**Consultation Response from KC,
Lead Local Flood Authority**

2020/93954 Land at, Lingards Road, Slaithwaite, Huddersfield, HD7 5HY

Erection of 43 dwellings and associated works

Date Responded: 30th November 2022

Detail
ROAD LONG SECTIONS

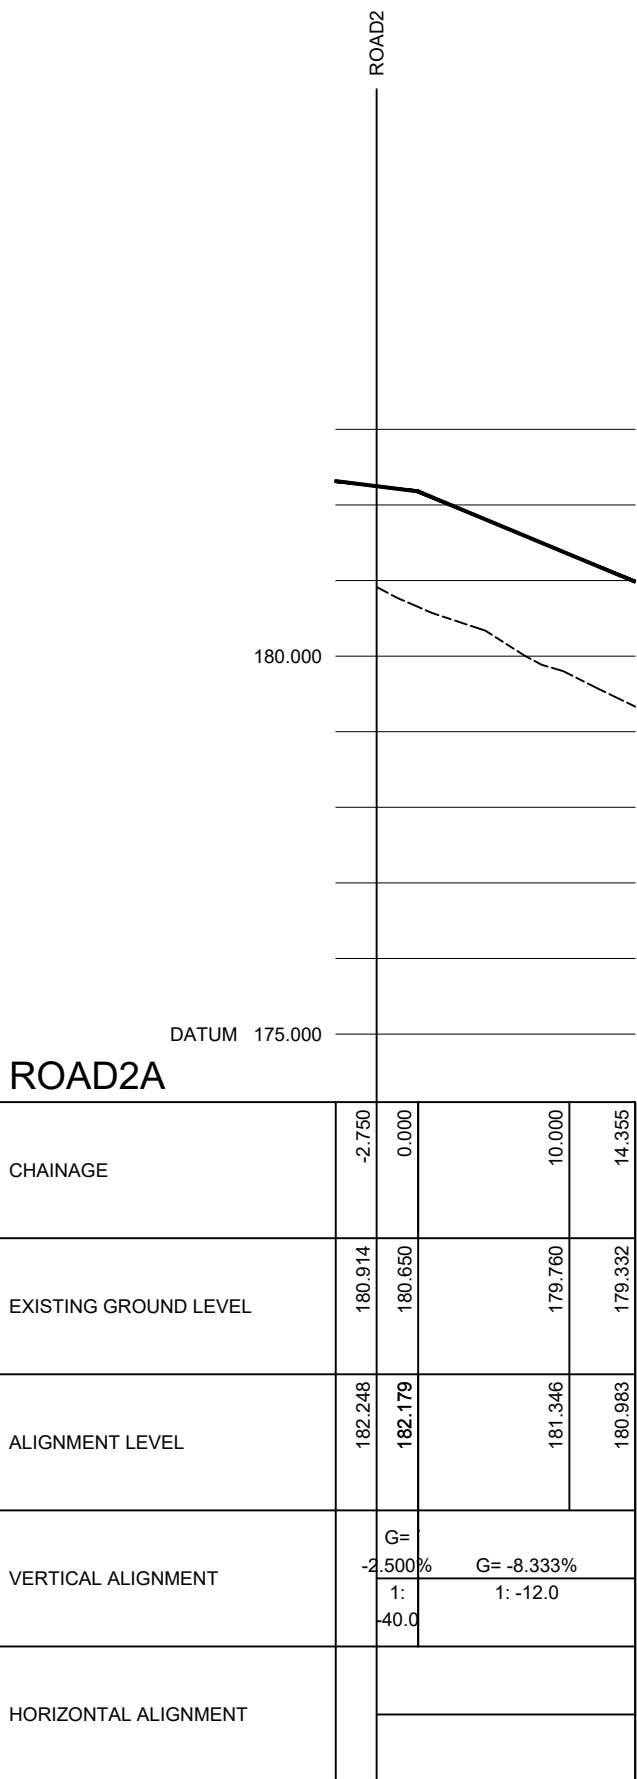
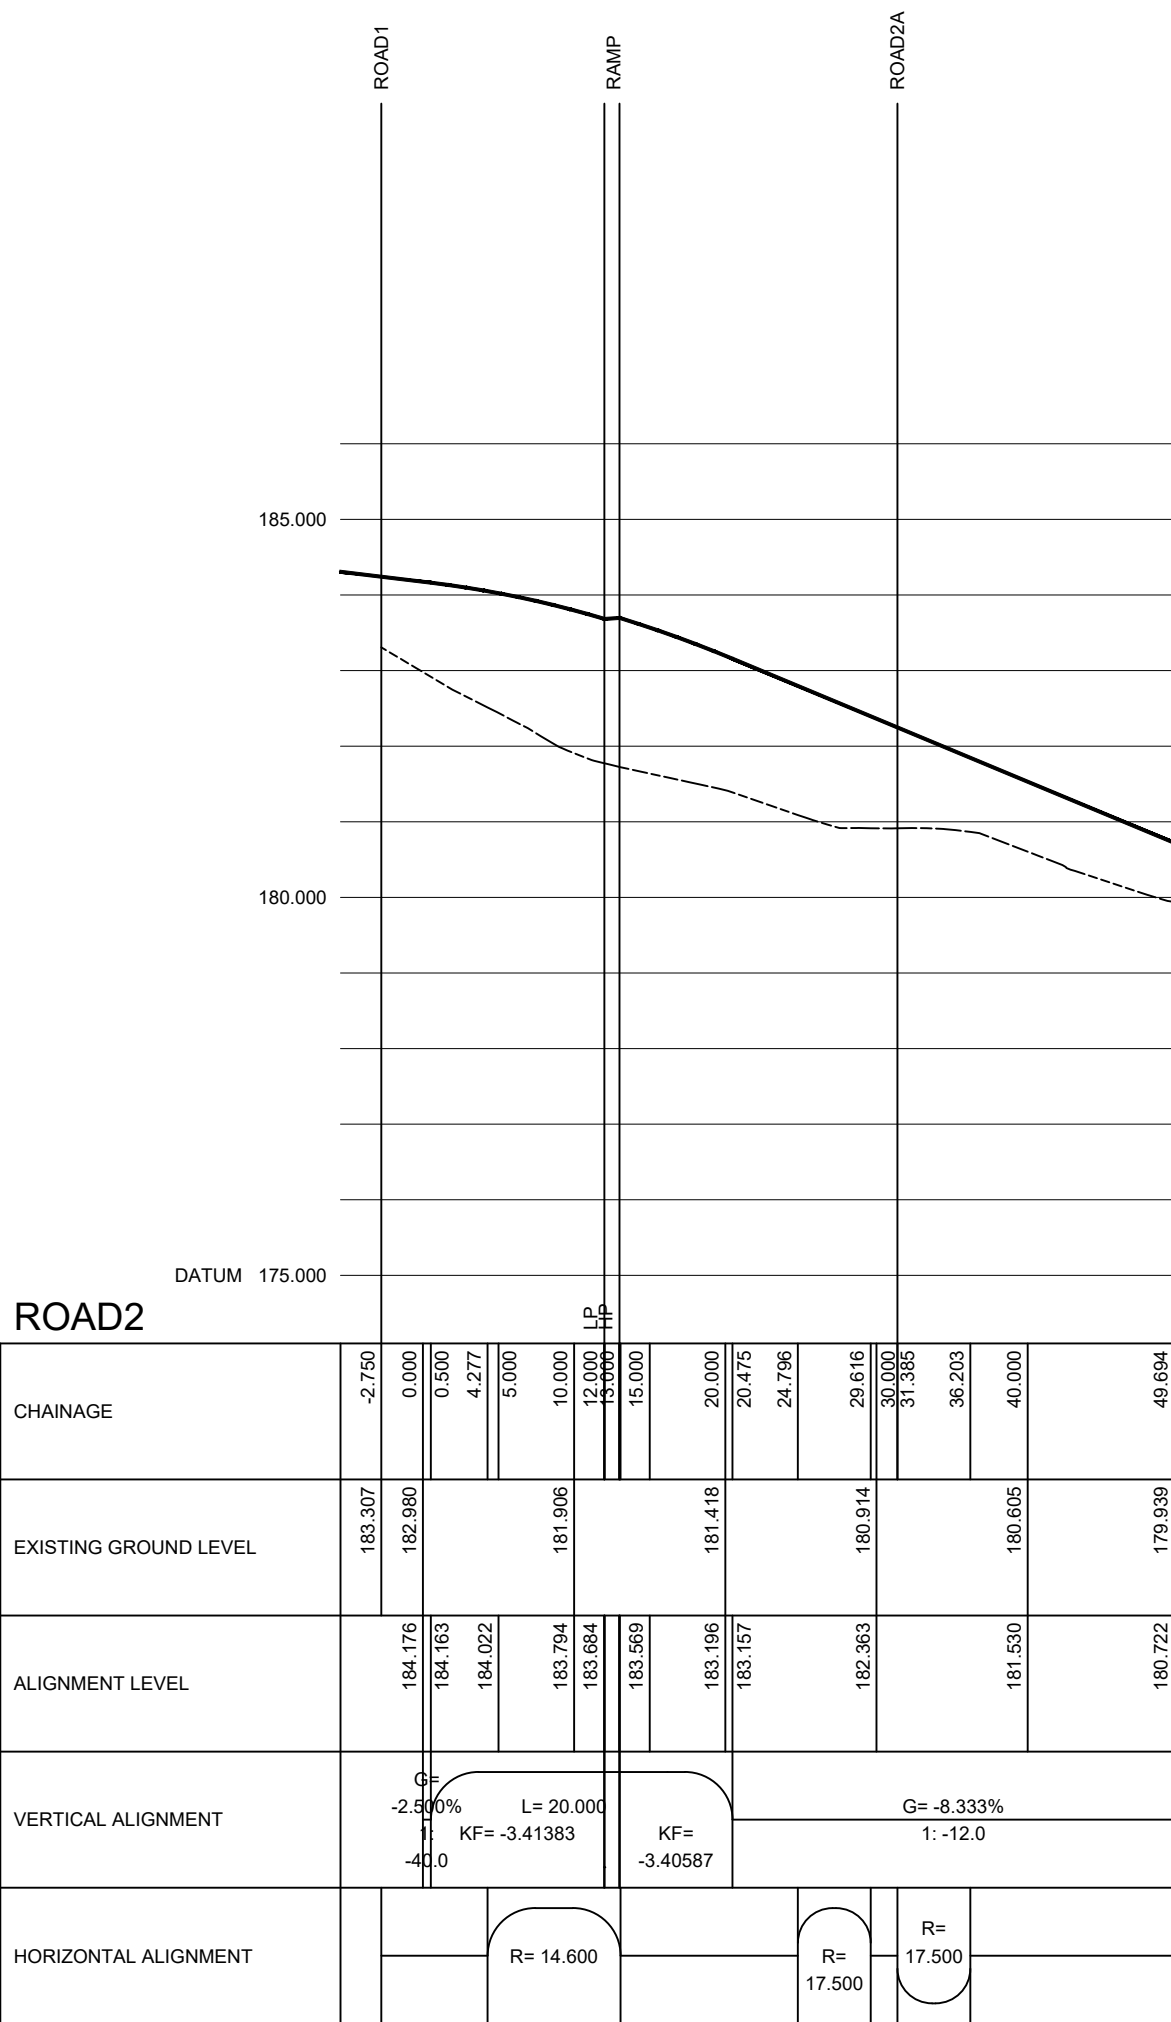
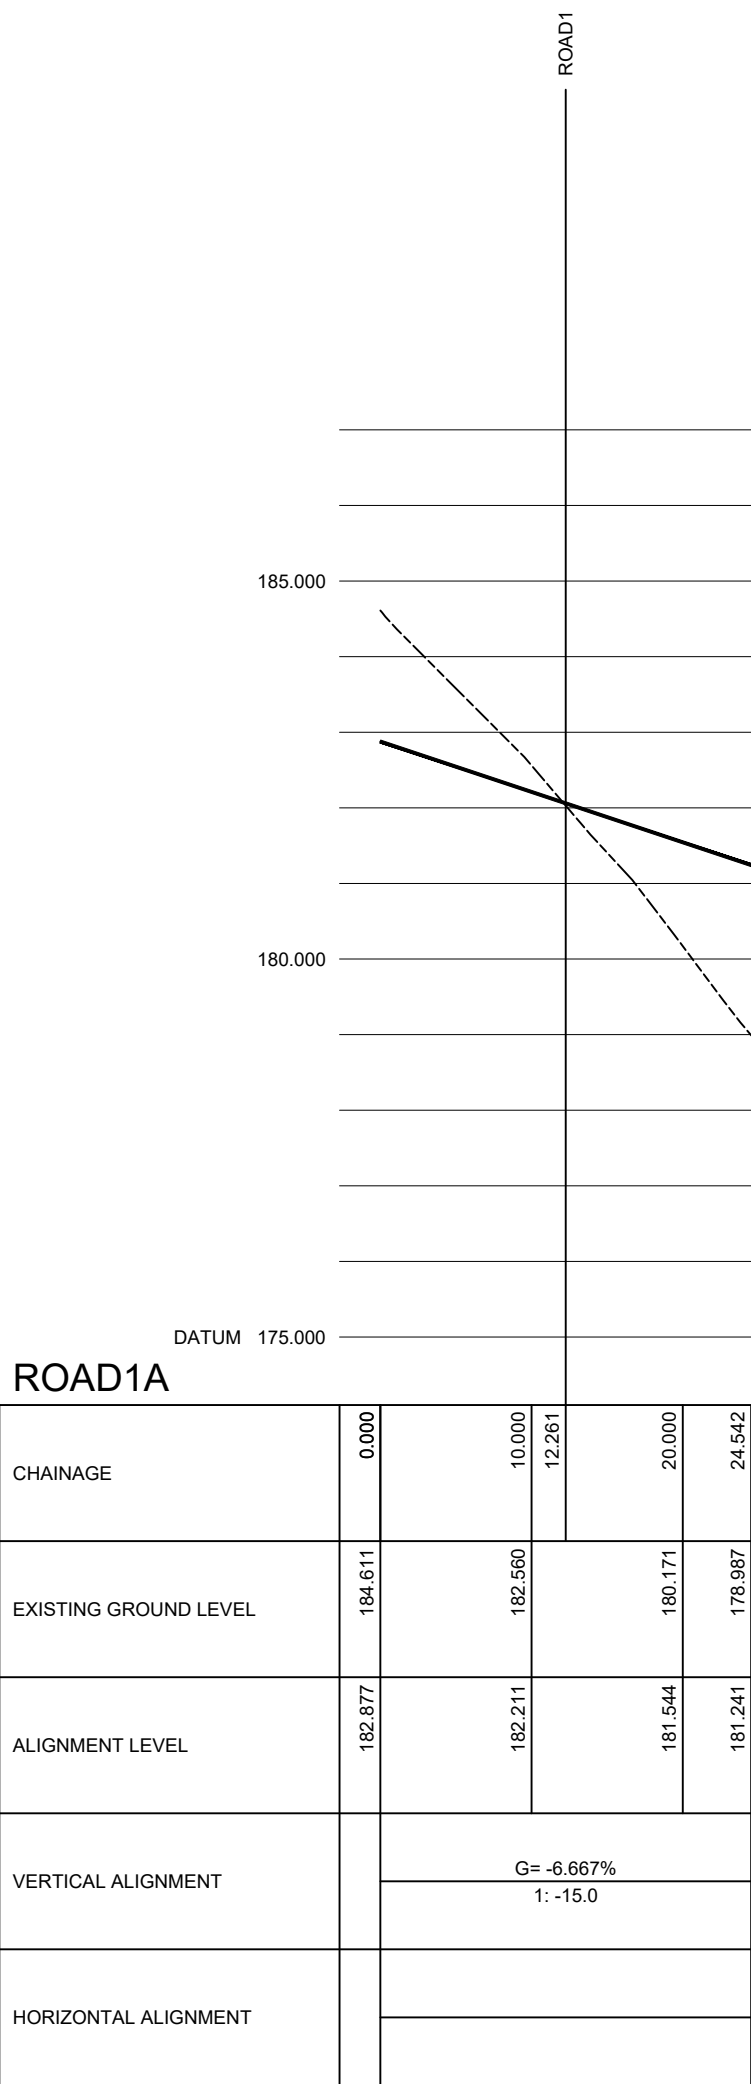
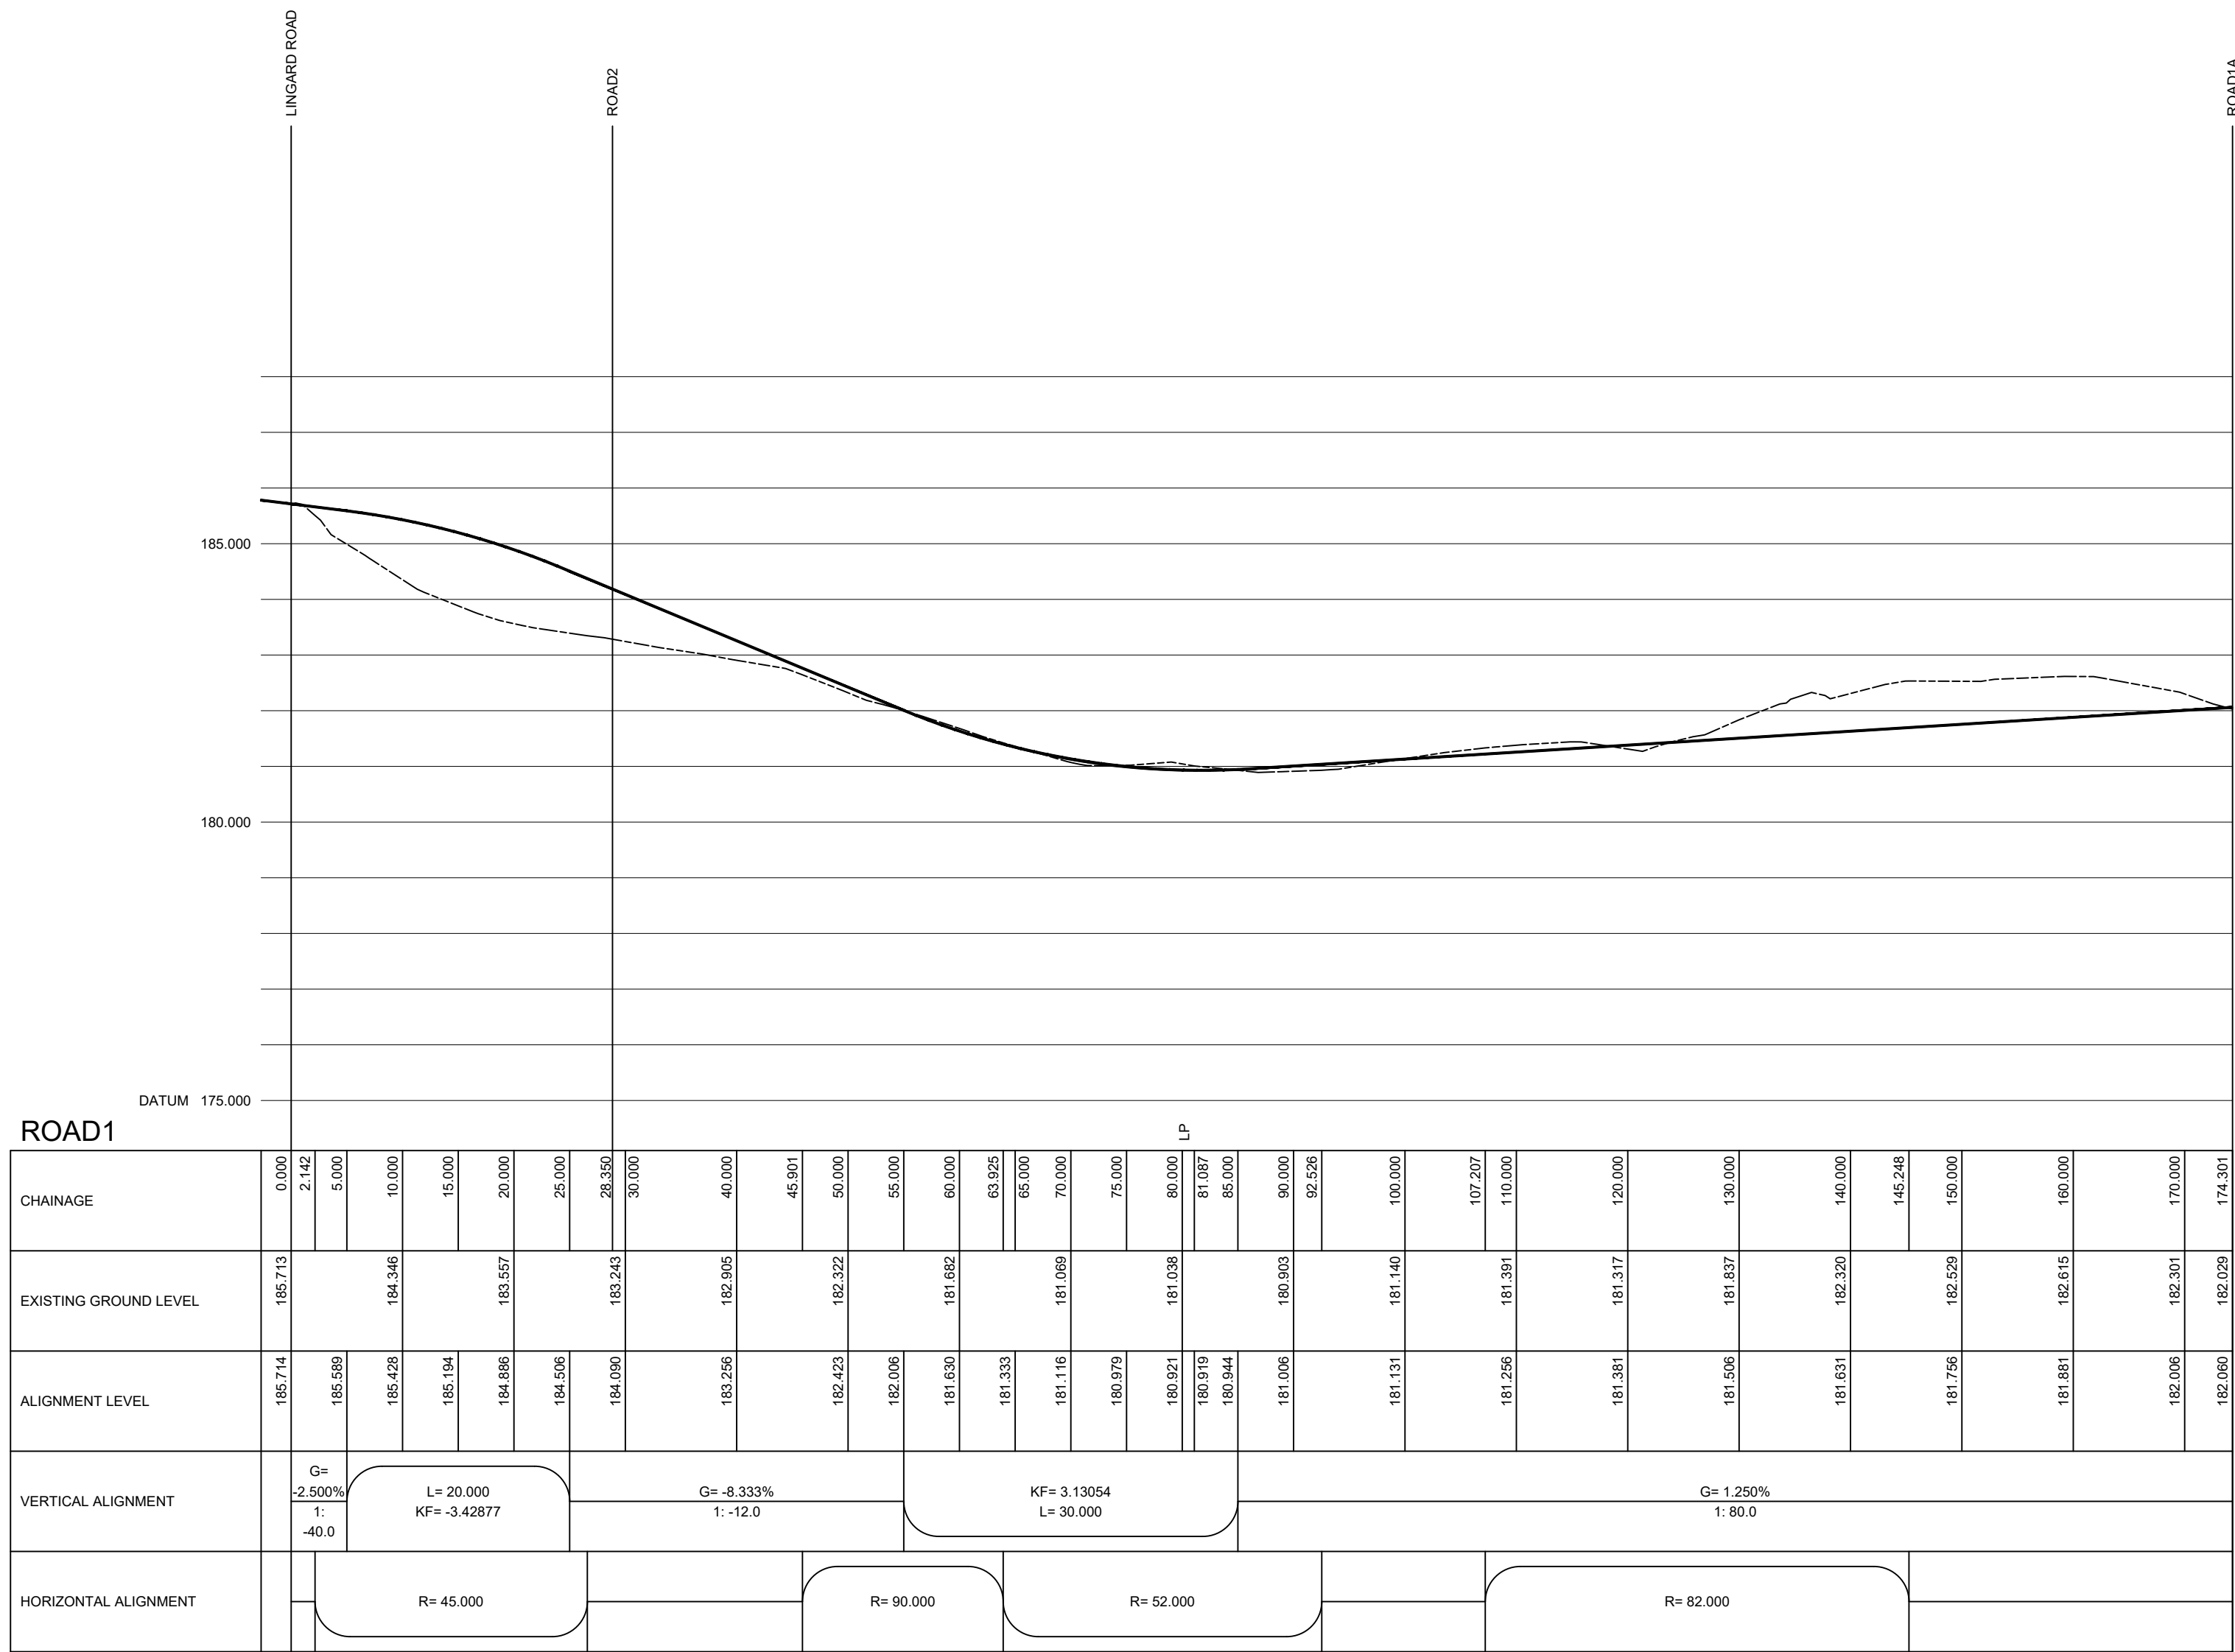
The route into site needs further clarification from where water goes if running overland at the S4 junction.
